From: Sue Howell
Sent: 28 February 2019 14:49
To: Planning.Responses
Cc: Michael Eastham
Subject: FW: Planning Consultation on WA/99/18/DOC

Further to submission of revised landscape details contained in dwgs CSA 3823-101-111 Rev B in relation to Condition 9 of this application WA/99/18/DOC I can recommend the following:

APPLICATION NO: WA/99/18/DOC

Site Address: Land East of Tye Lane Walberton Arun

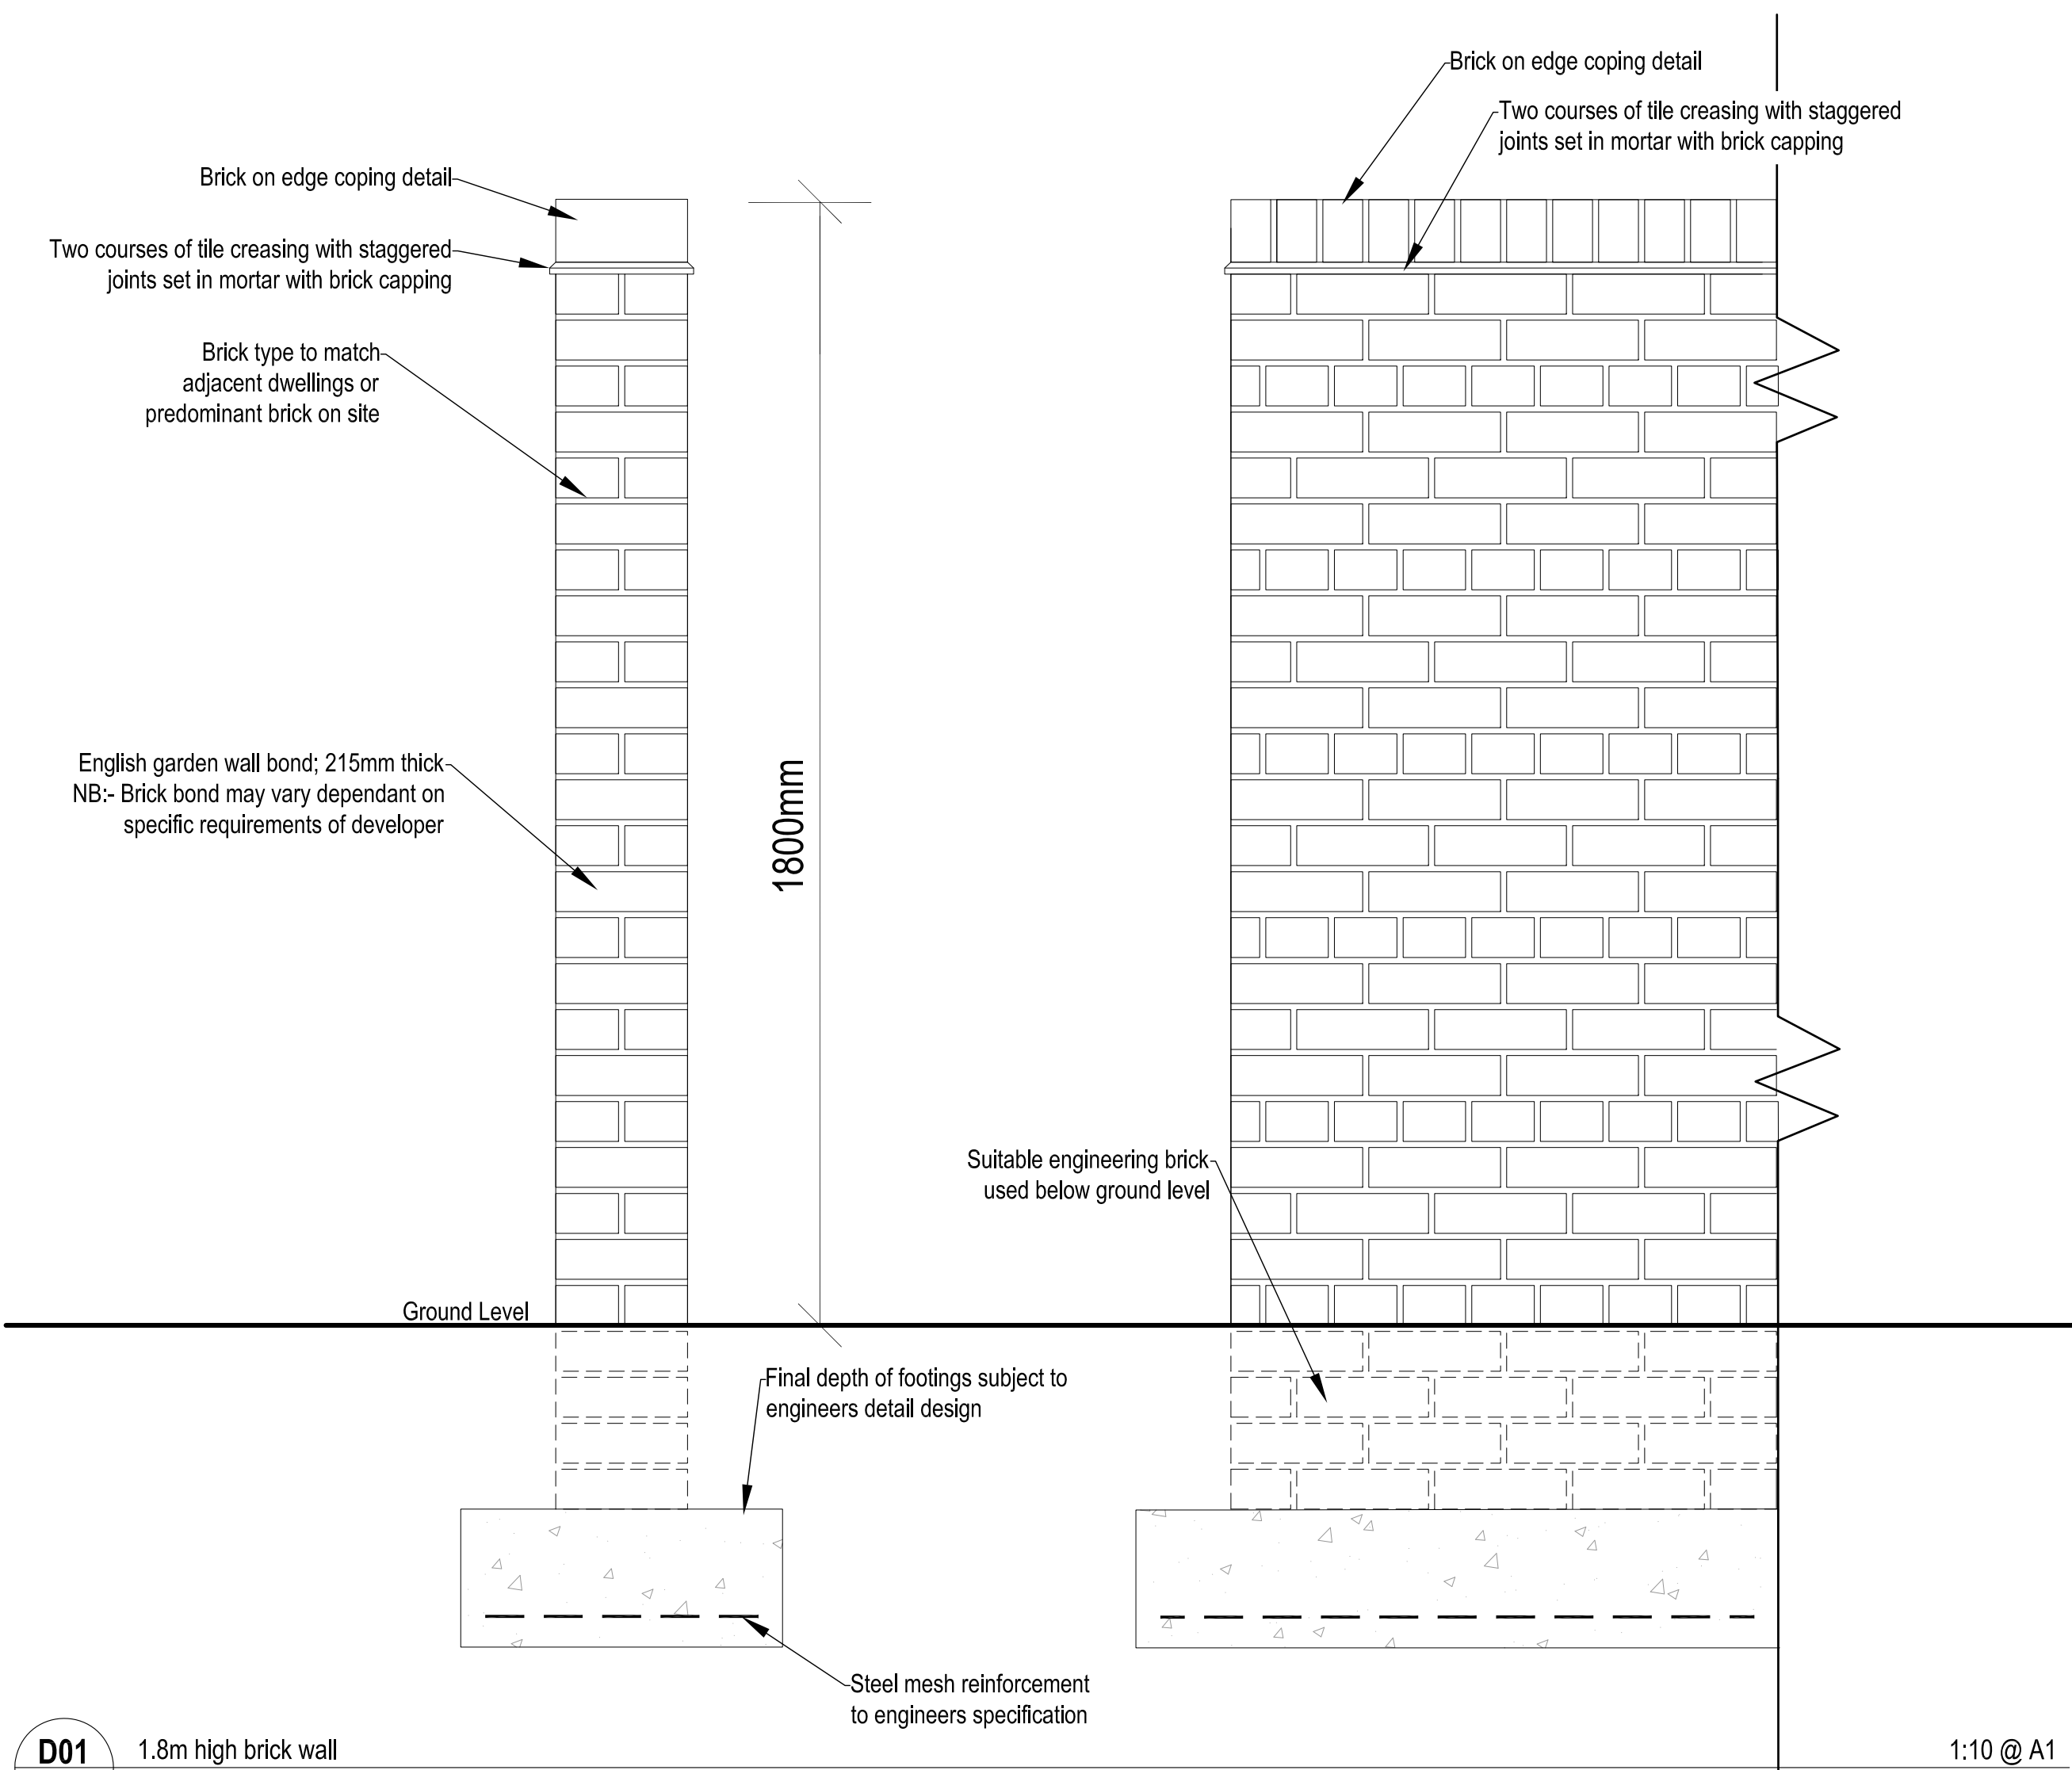
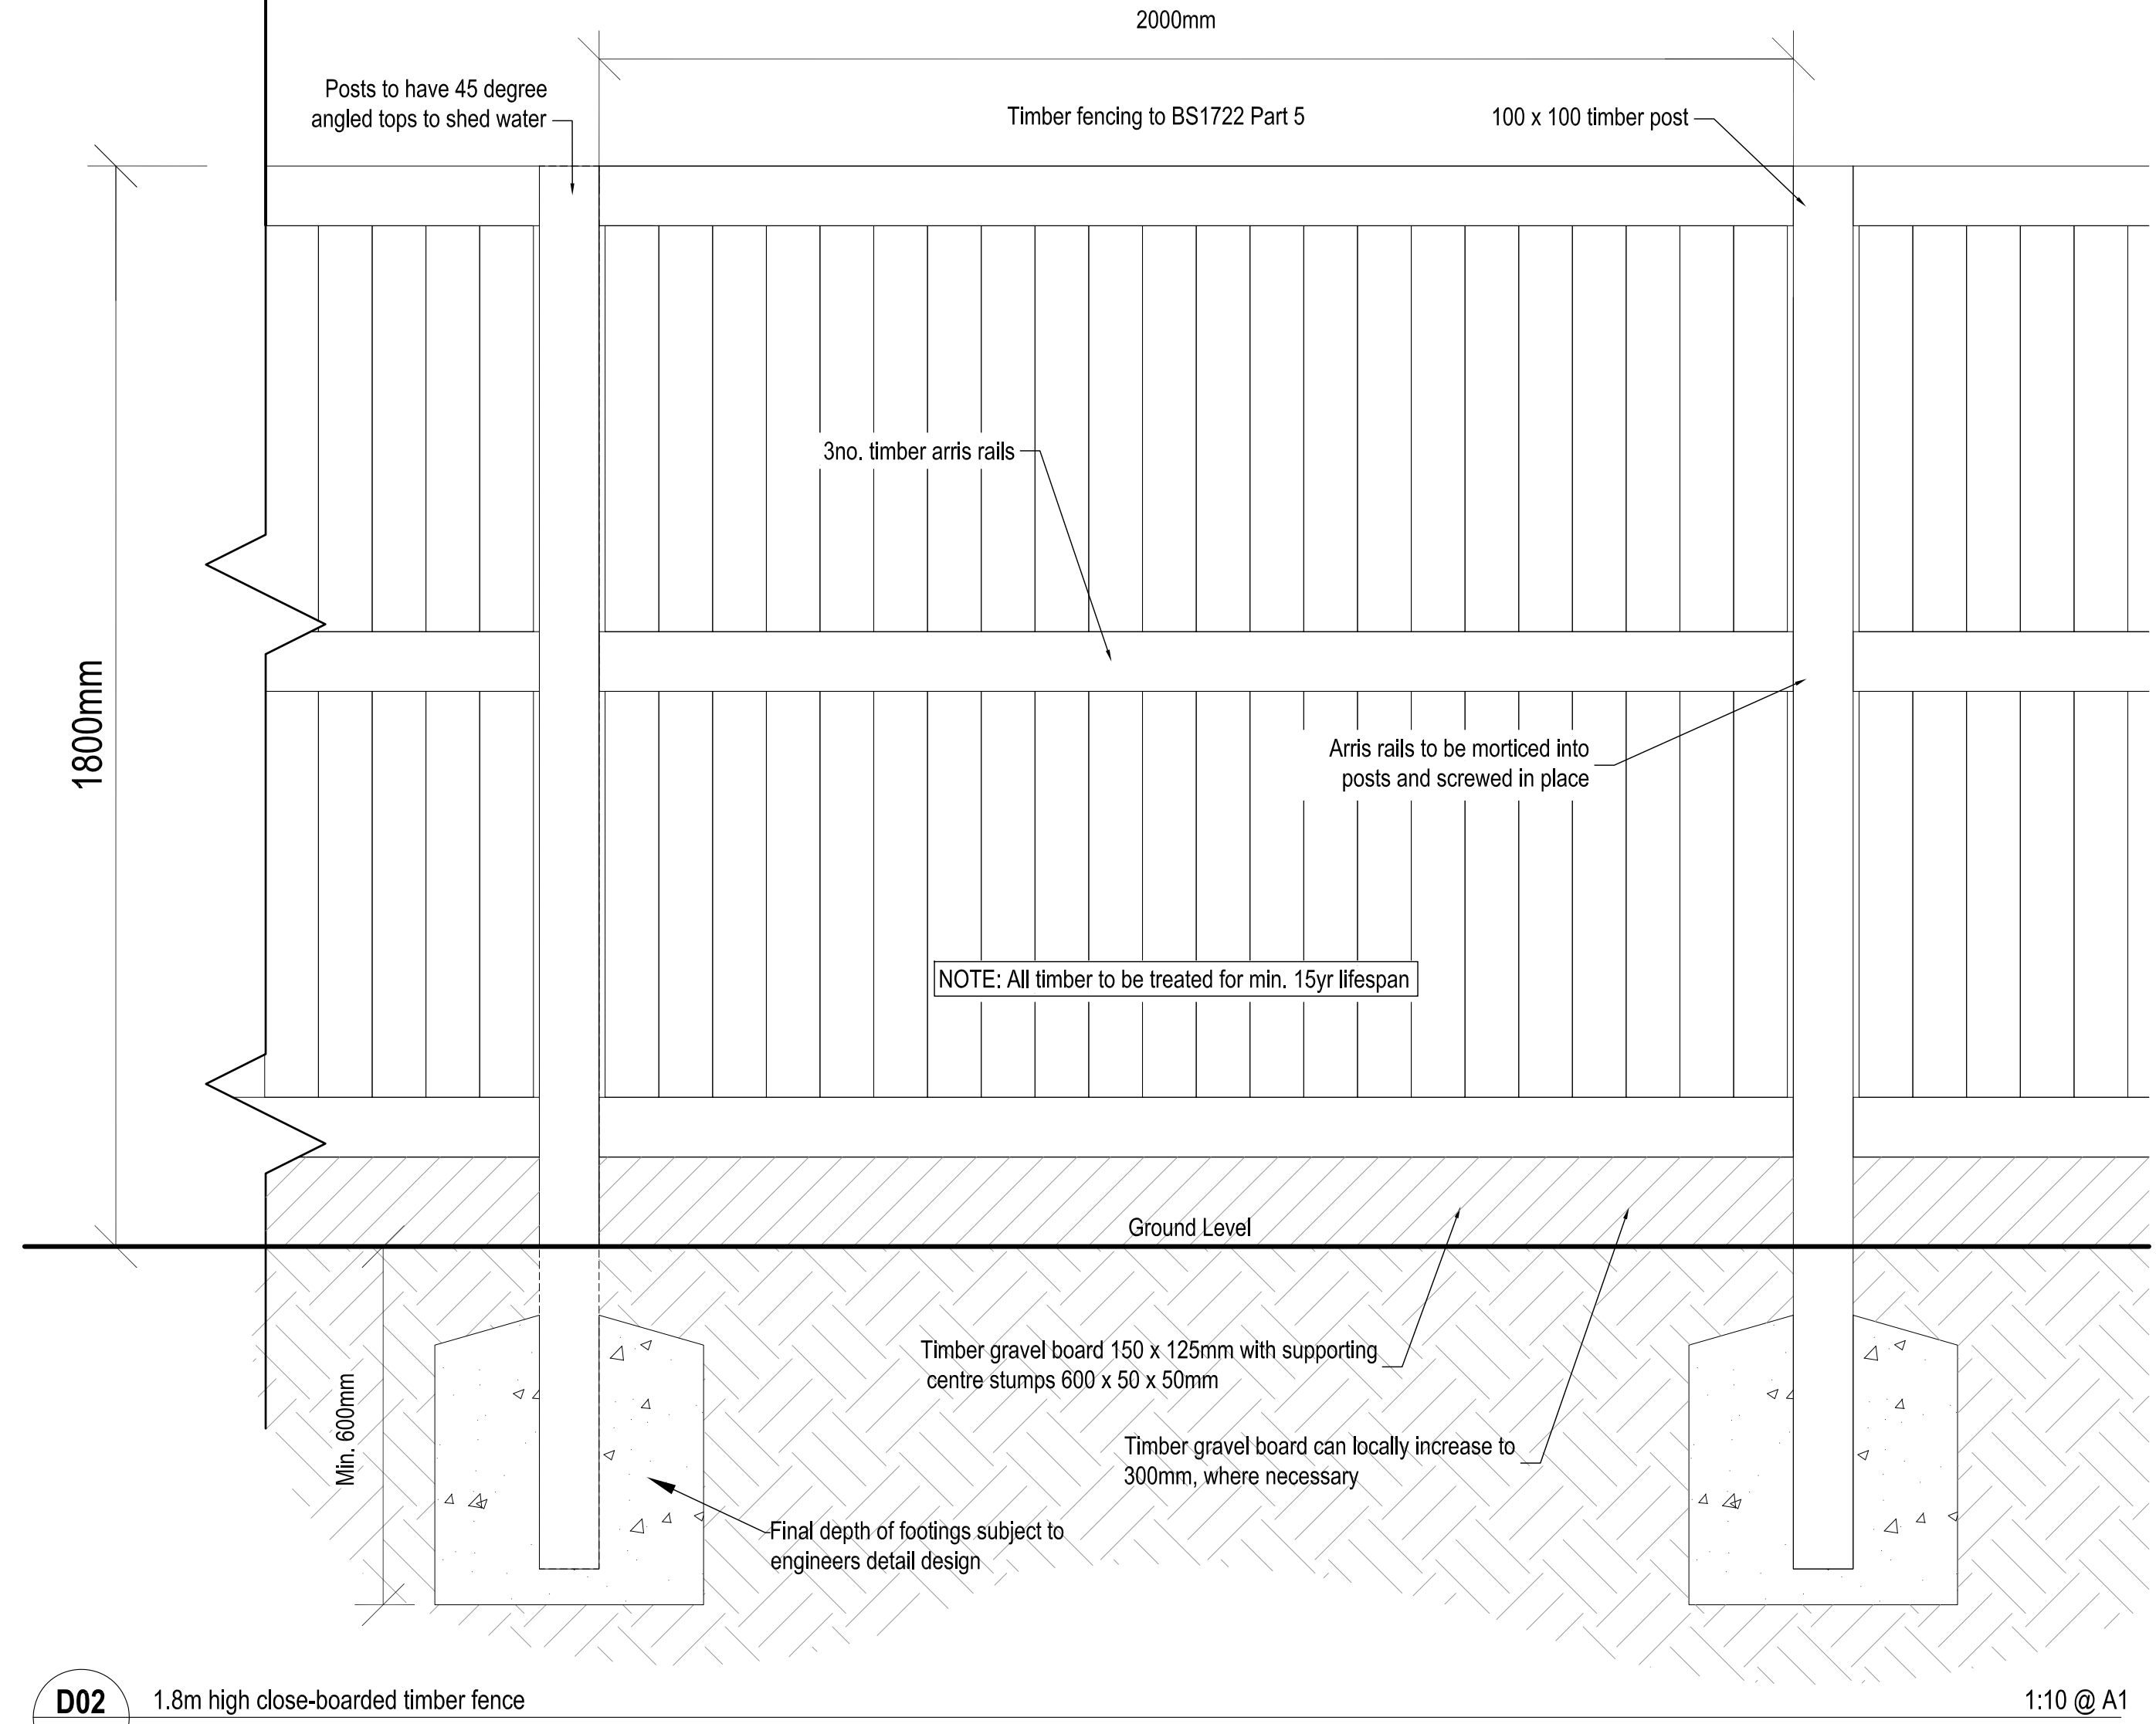
- II. Details re height, design and type of boundary treatment have been provided.
- III. Crown spread and location of trees to be retained have been shown in location within masterplan and detailed landscape drawings and the topography in which these sit.

I would therefore **recommend discharge of Condition 9** landscape details contained in this reserved matters application WA/95/18/RES following outline consent WA/44/17/OUT.
